**From:** [Luke Joseph](#)  
**To:** [Ferdinando Macri](#)  
**Cc:** [Jim Baldwin](#); [Elise Mangion](#)  
**Subject:** HPE CM: RE: Notice of Exhibition - SSD-17491477 - Lang Walker AO Medical Research Building - Macarthur - Council  
**Date:** Friday, 28 January 2022 10:16:17 AM  
**Attachments:** [image002.png](#)  
**Importance:** High

Council is supportive of this application, and considers the proposed development a welcome investment into the planned health and innovation precinct of the Campbelltown City Centre.

2 LOWER GROUND 01

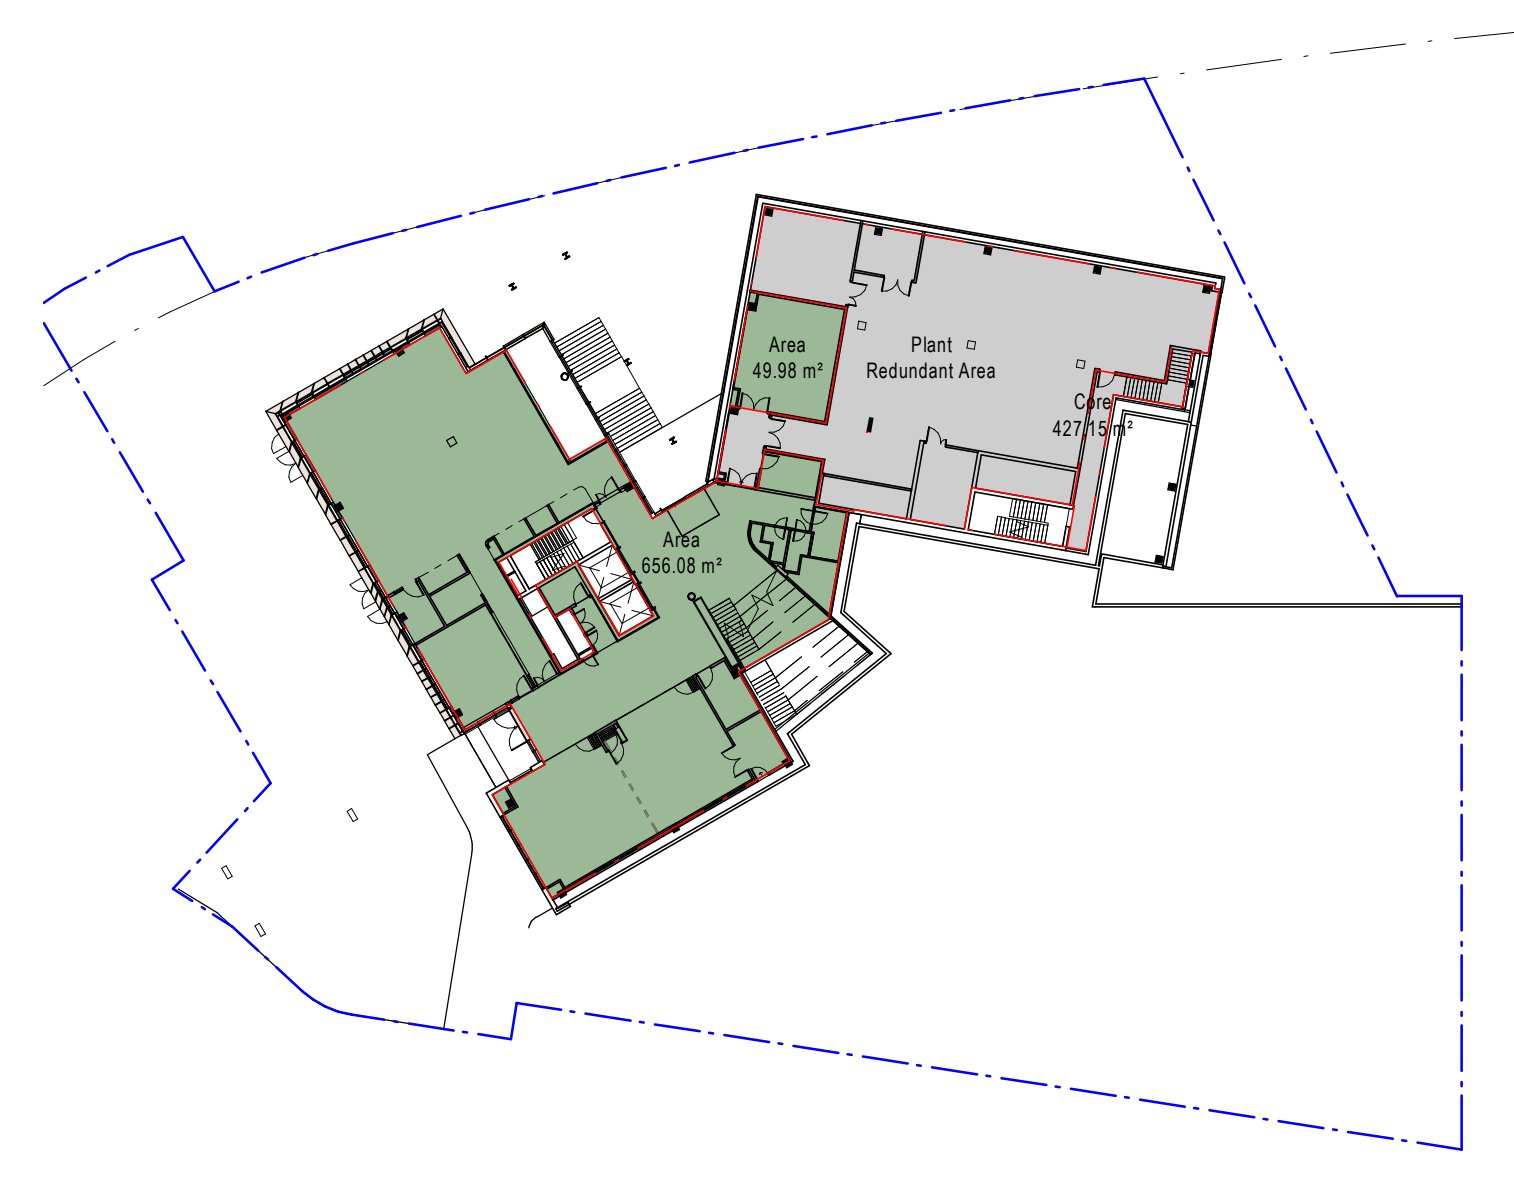
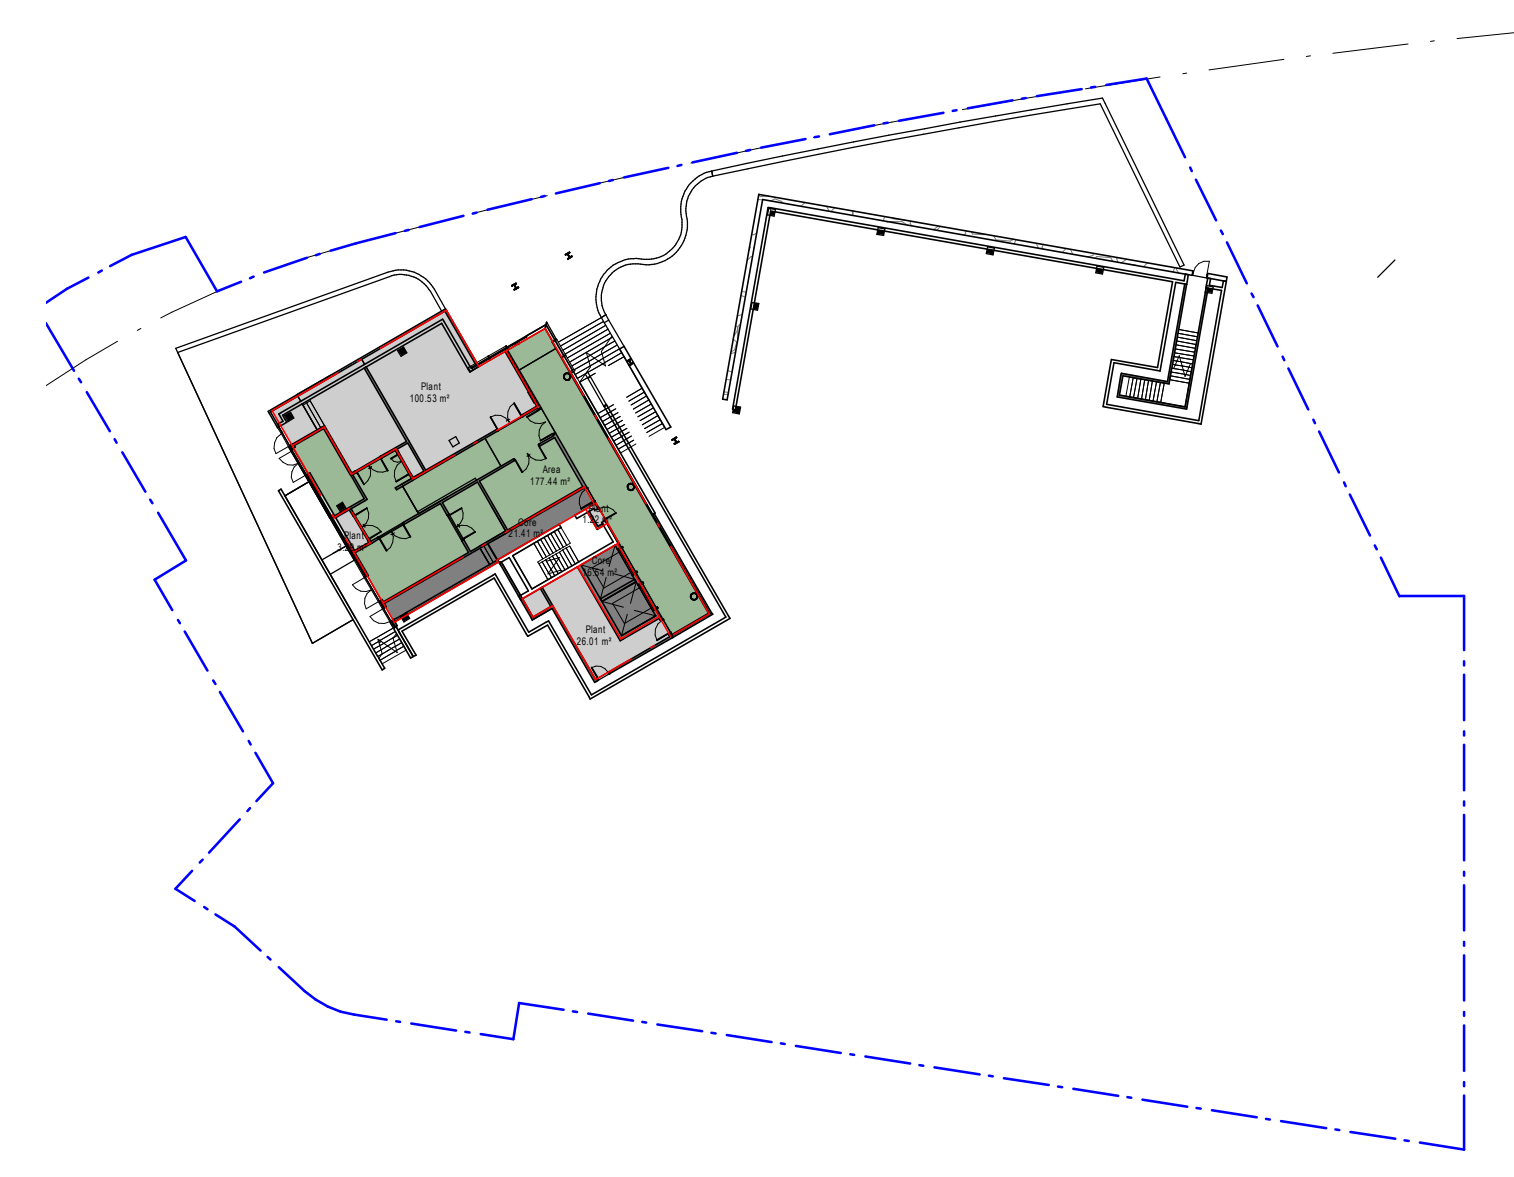
1. An improvement in the appearance of the lower sections of the west-facing facades of the proposed building would be welcome, specifically the southern part of level lower ground 02 and the northern part of level lower ground 01. These parts of the building generally contain street-facing walls that are somewhat blank. If the nature of the floor space adjoining these walls precludes activation and visual transparency, Council would appreciate the walls being enhanced architecturally to provide visual interest in this highly visible location.

Figure A1 - Existing Overland Flow Path at Southern Site Boundary

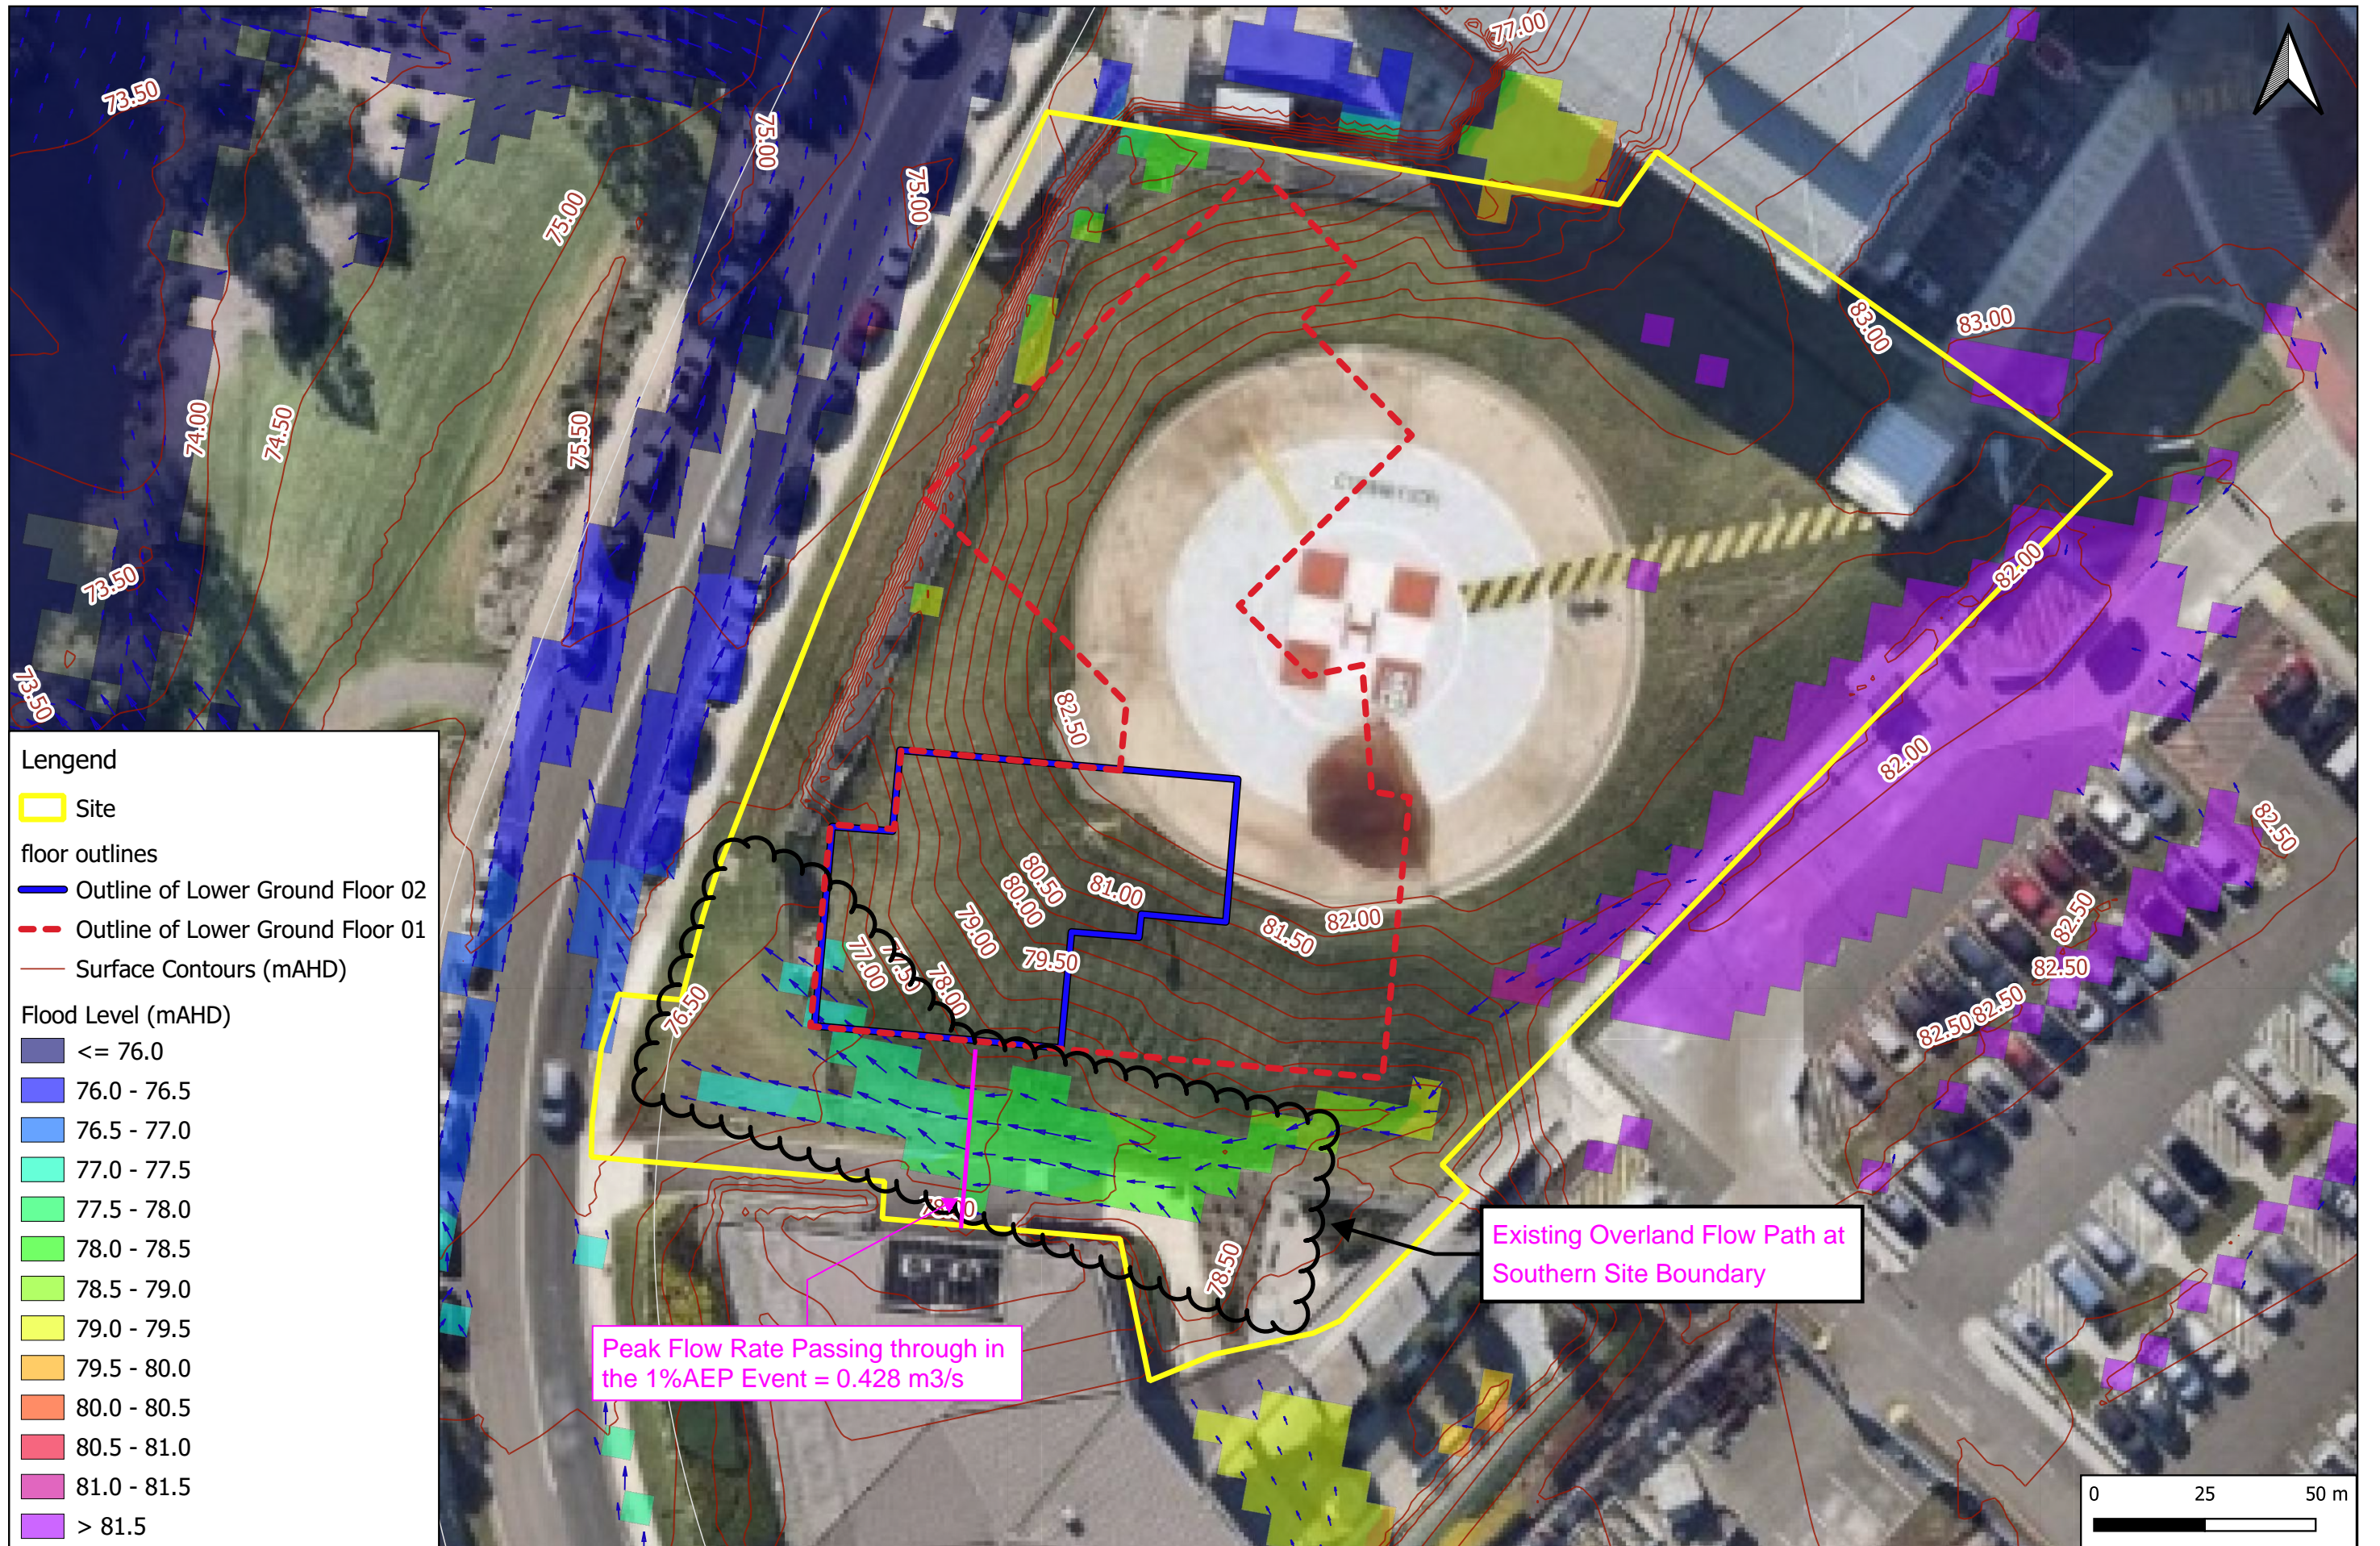
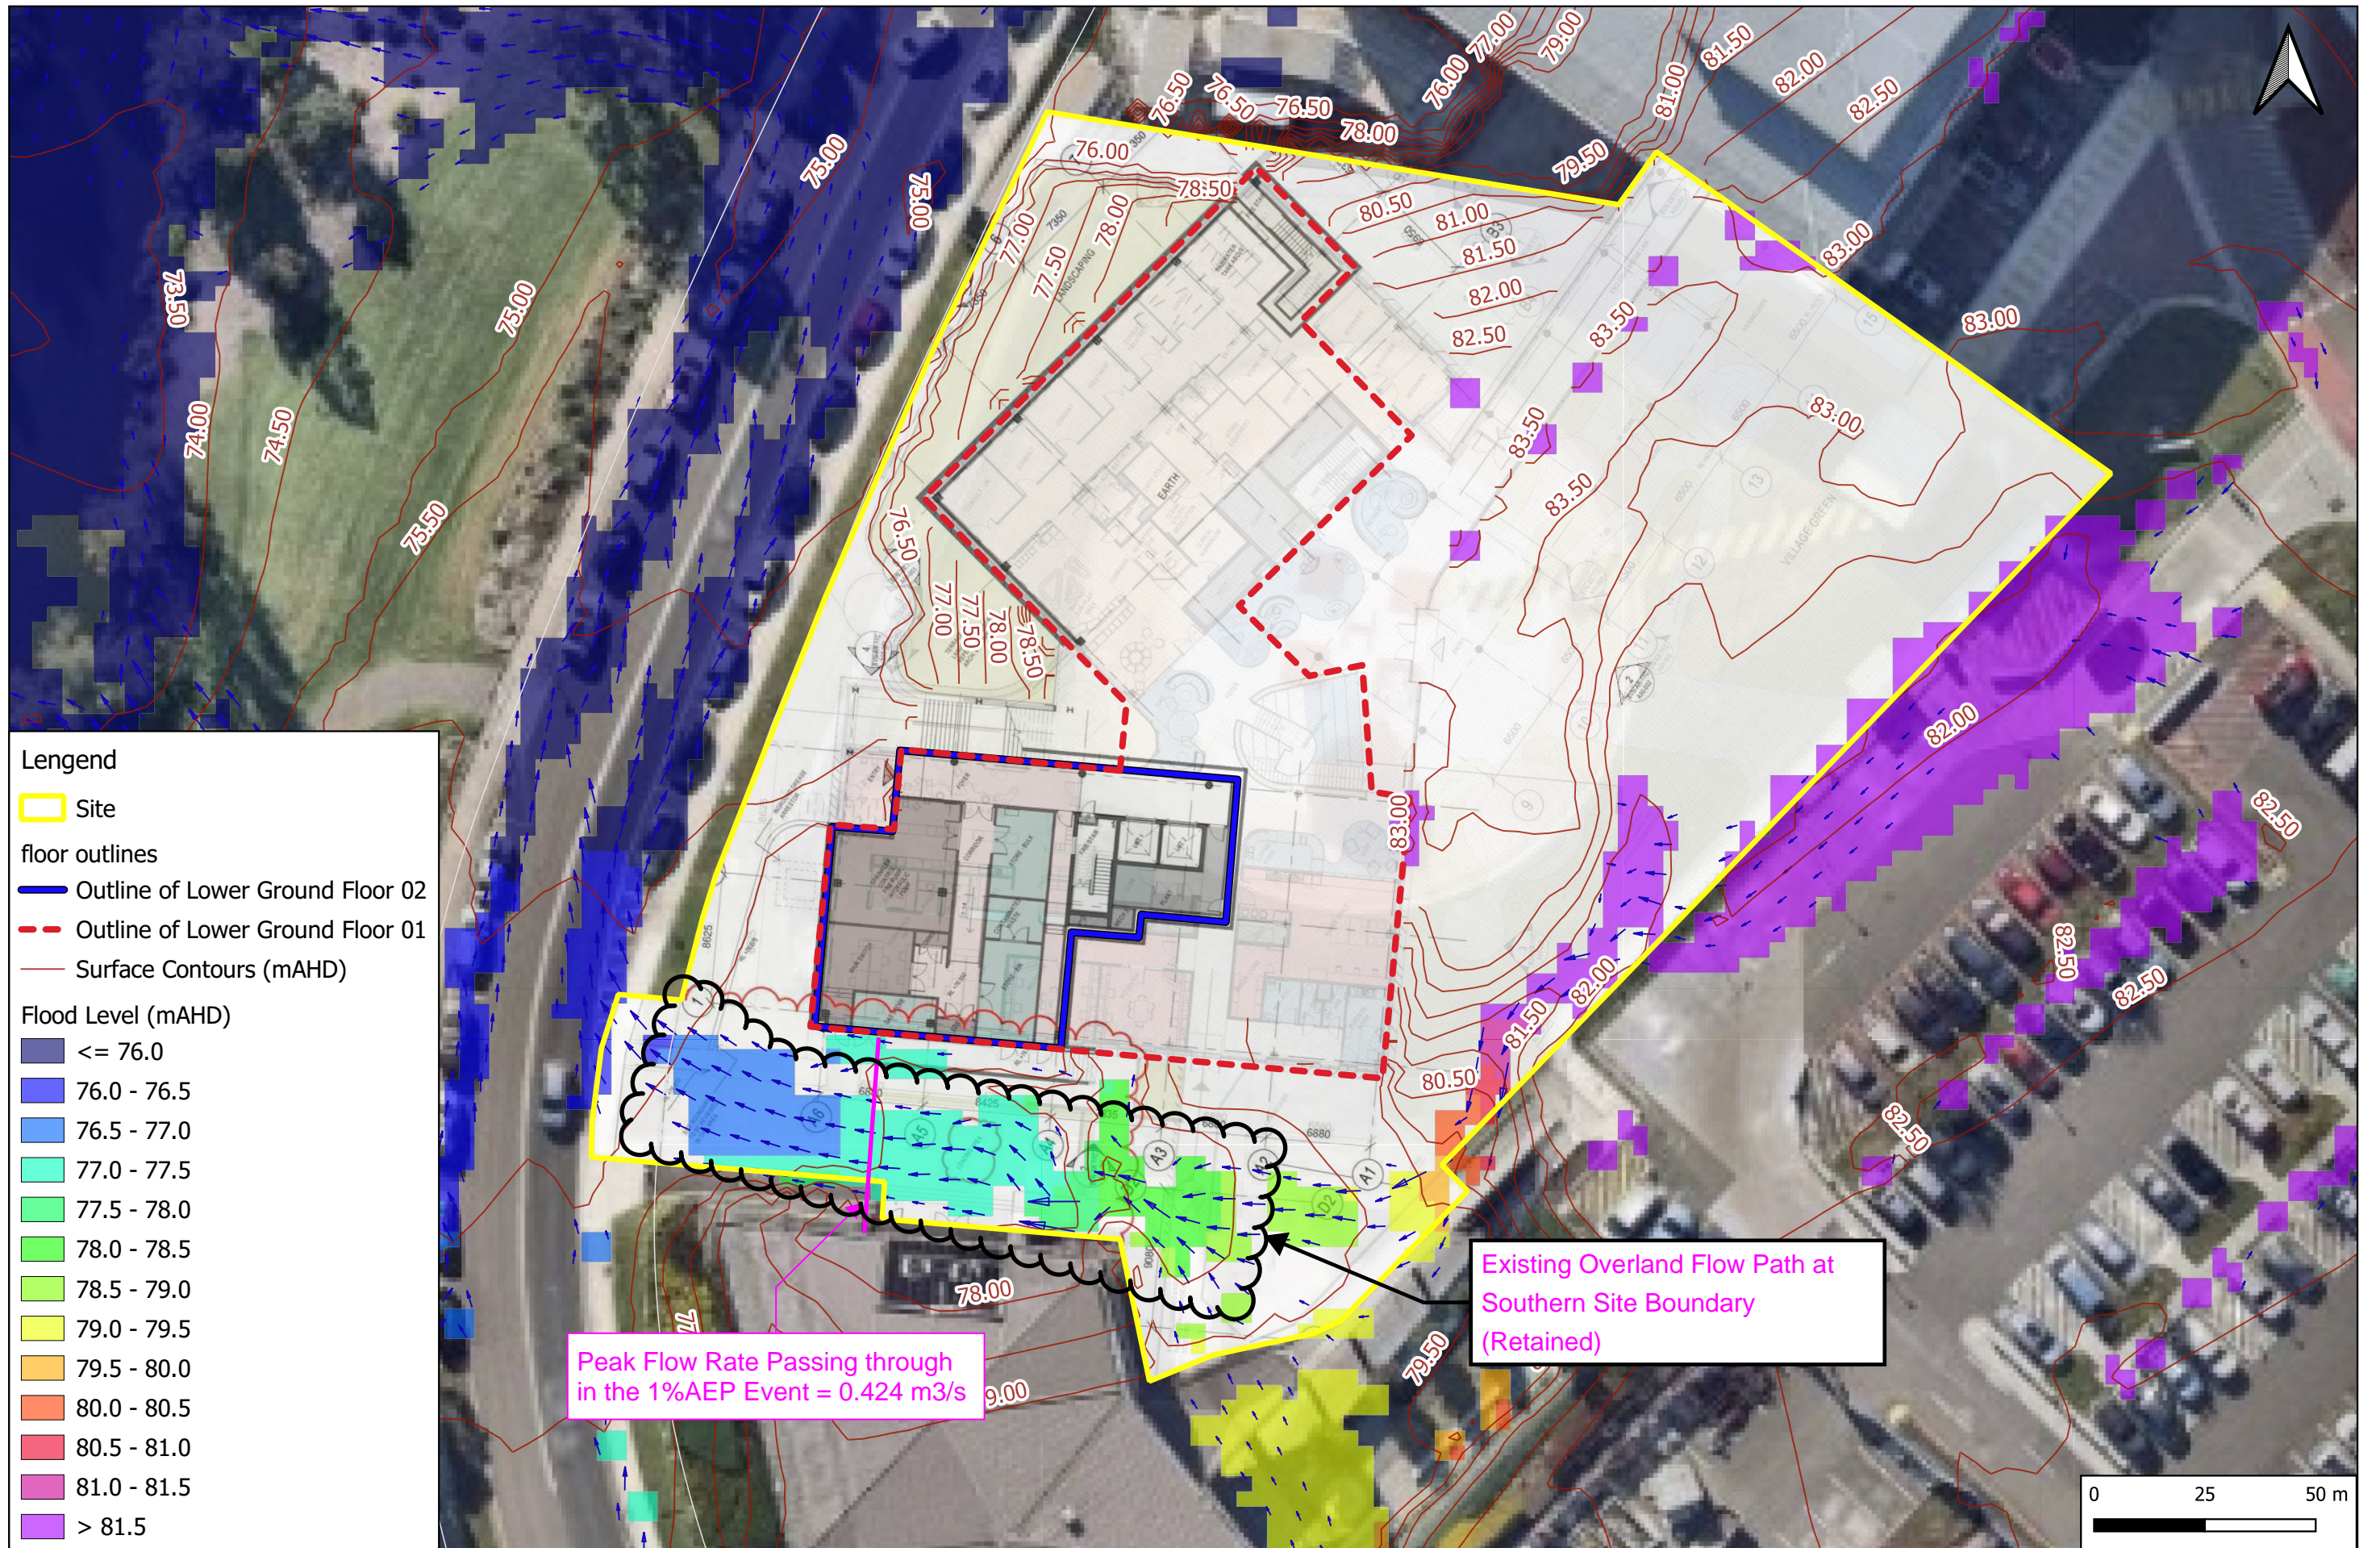
4. The site is impacted by overland flow from the car park at the hospital. Council discussed this matter with the proponent's engineers previously, and it was indicated that an overland flow path to the north of the proposed building would be included in the design. This flow path is not evident on the plans, however it is needed and should collect the overland flow and manage its discharge to the pipe drainage system in Parkside Crescent. Overland flows over the footpath, or discharge to the road surface are not permissible.
